Addendum #2

**The Parkside Neighborhood Center
and Affordable Housing
Mellen & Grant Streets,
Portland, Maine 04101**

February 20,2004

TFH Architects
100 Commercial St.
Portland, Maine 04101

1 LIVING / DINING ROOM # 208, 209
1/4" = 1'-0"

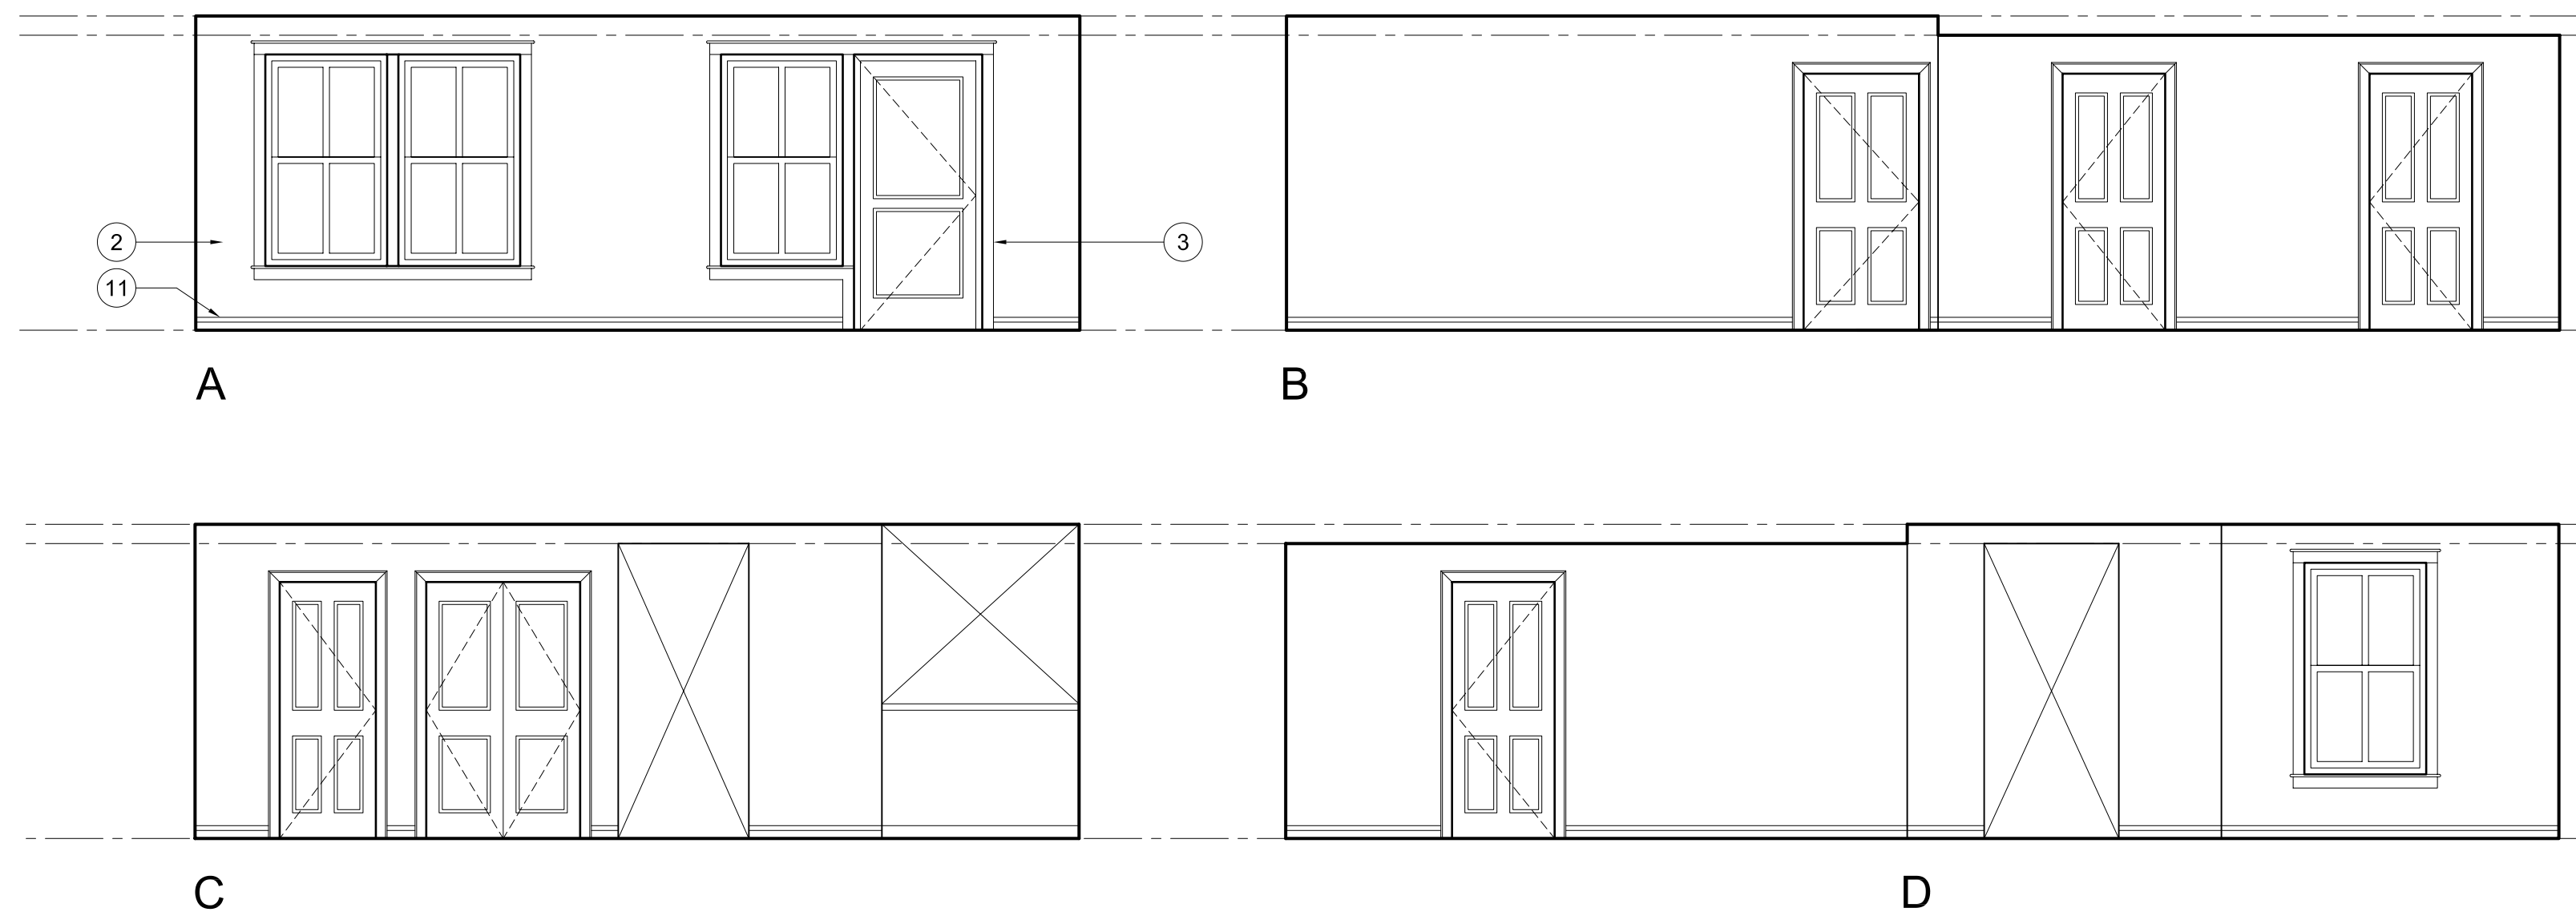
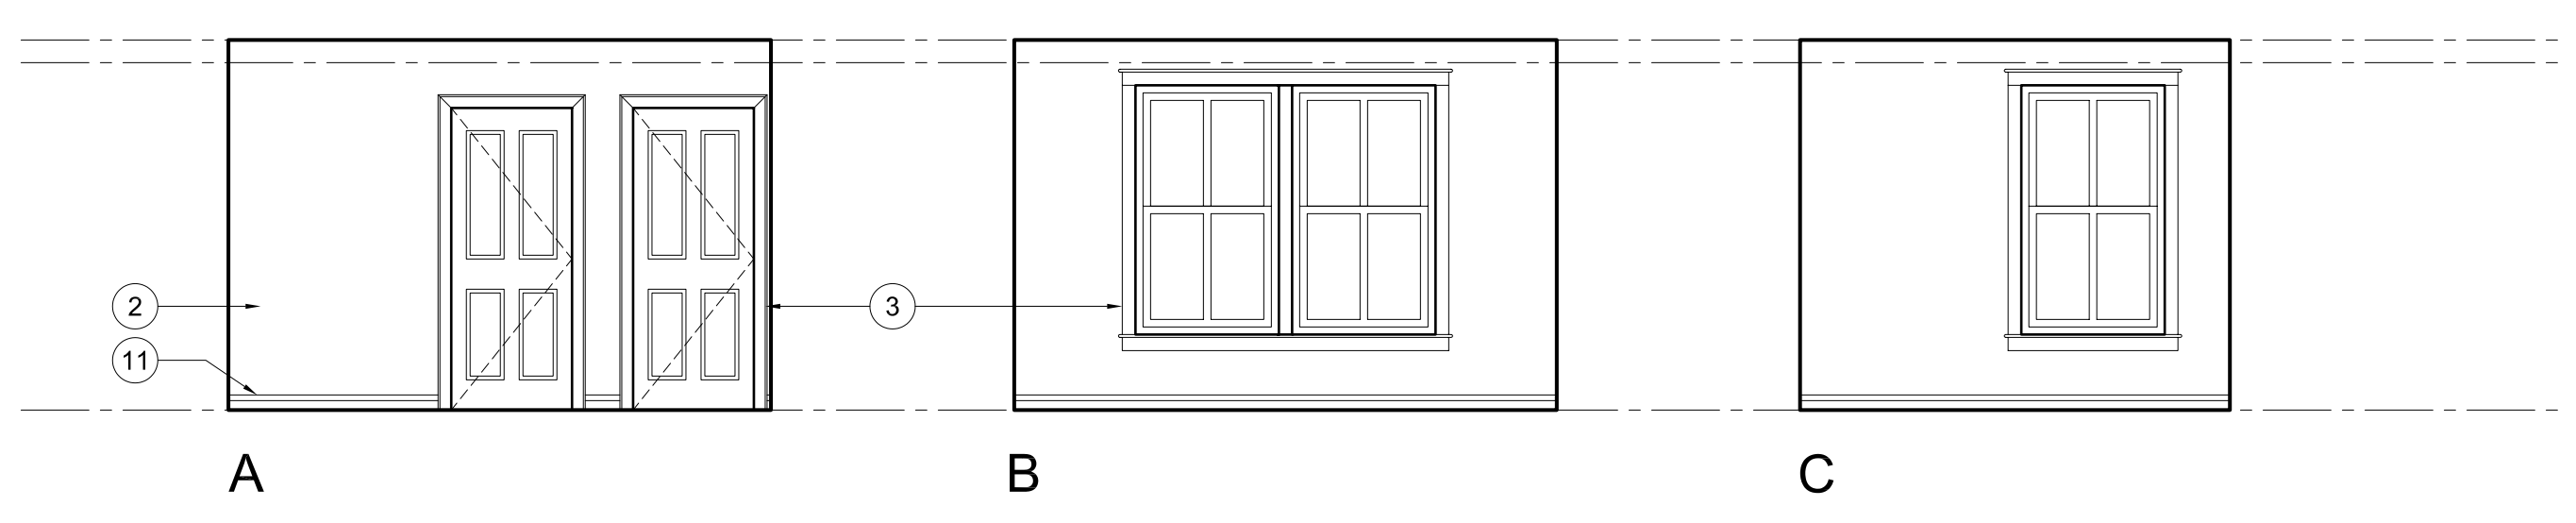
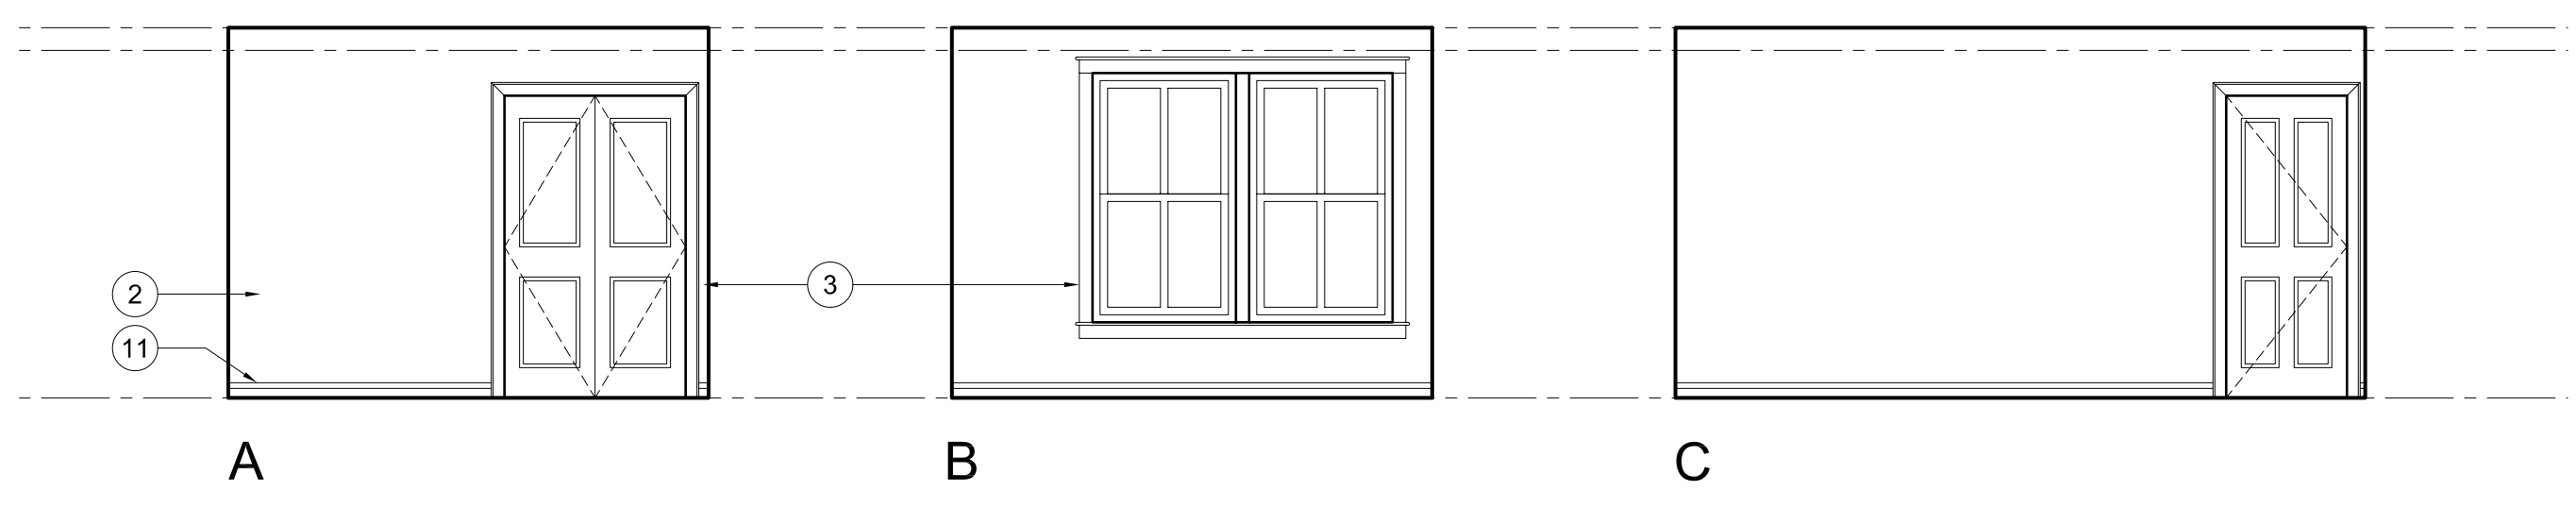
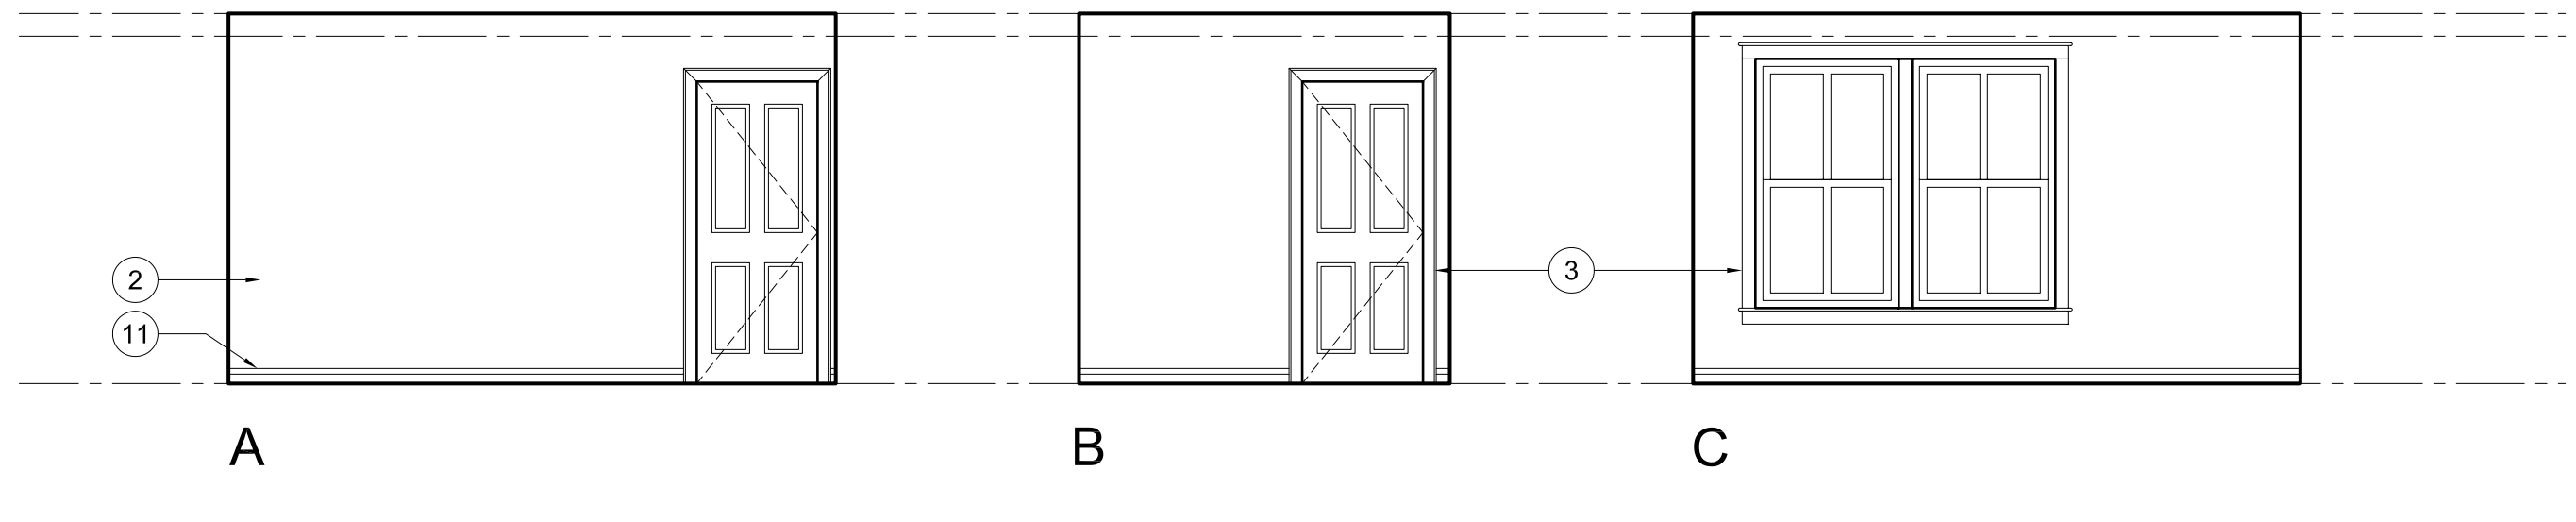
- 2-29 CLARIFICATION
Residential unit elevations on sheet A3.2 are indicative of most, but not all conditions. Bidders should use floor plans, reflected ceiling plans and unit elevations as a guide to determining all layouts.

5 KITCHEN, ROOM # 207
1/4" = 1'-0"

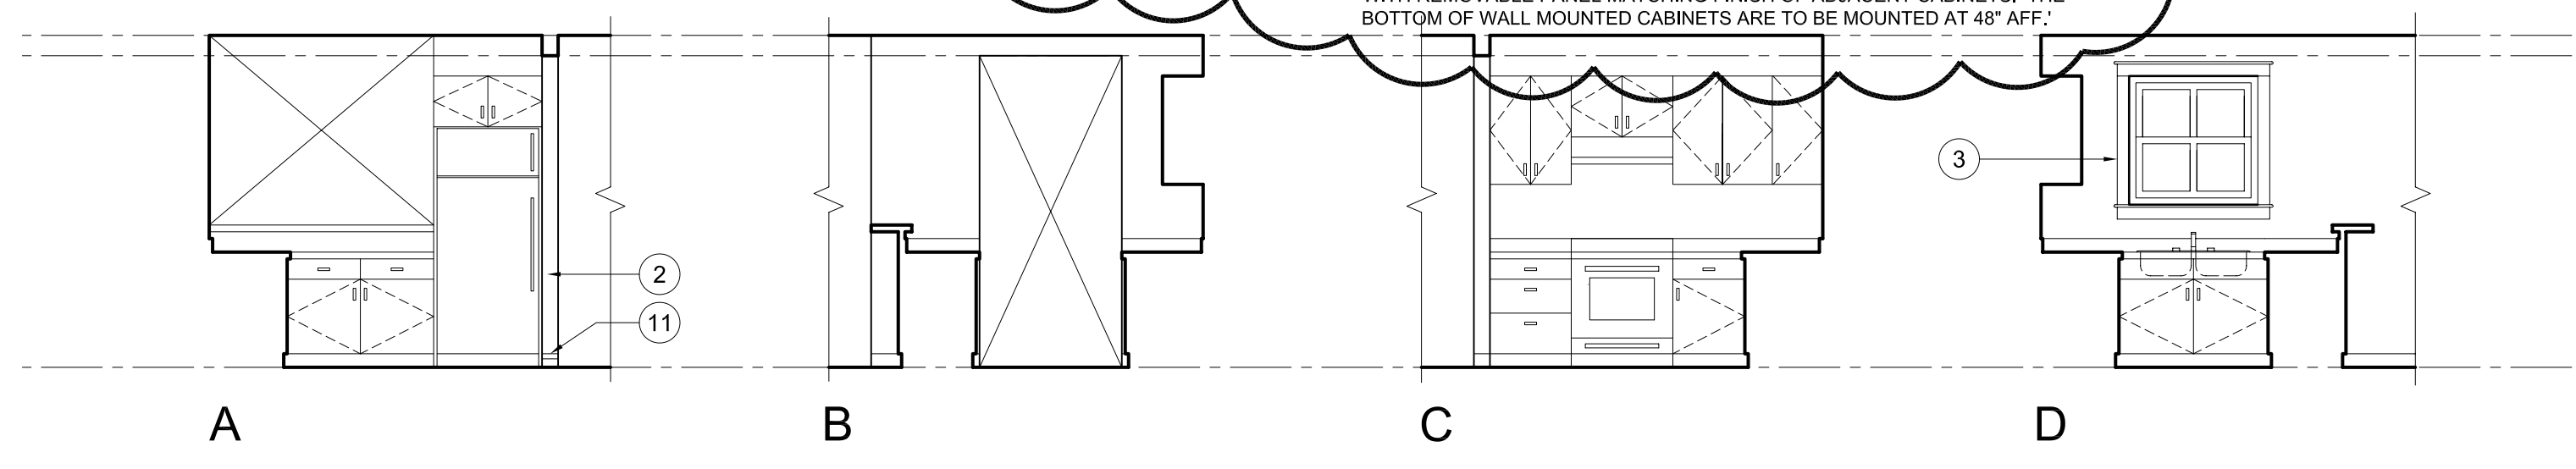
- 2-28 QUESTION
On sheet A3.2, # 5 B D, should there be a framed wall below the raised counter top?
ANSWER
Yes, a framed wall should be included in the counter depth to support the counter. When not end supported brackets should also be provided for sufficient support.
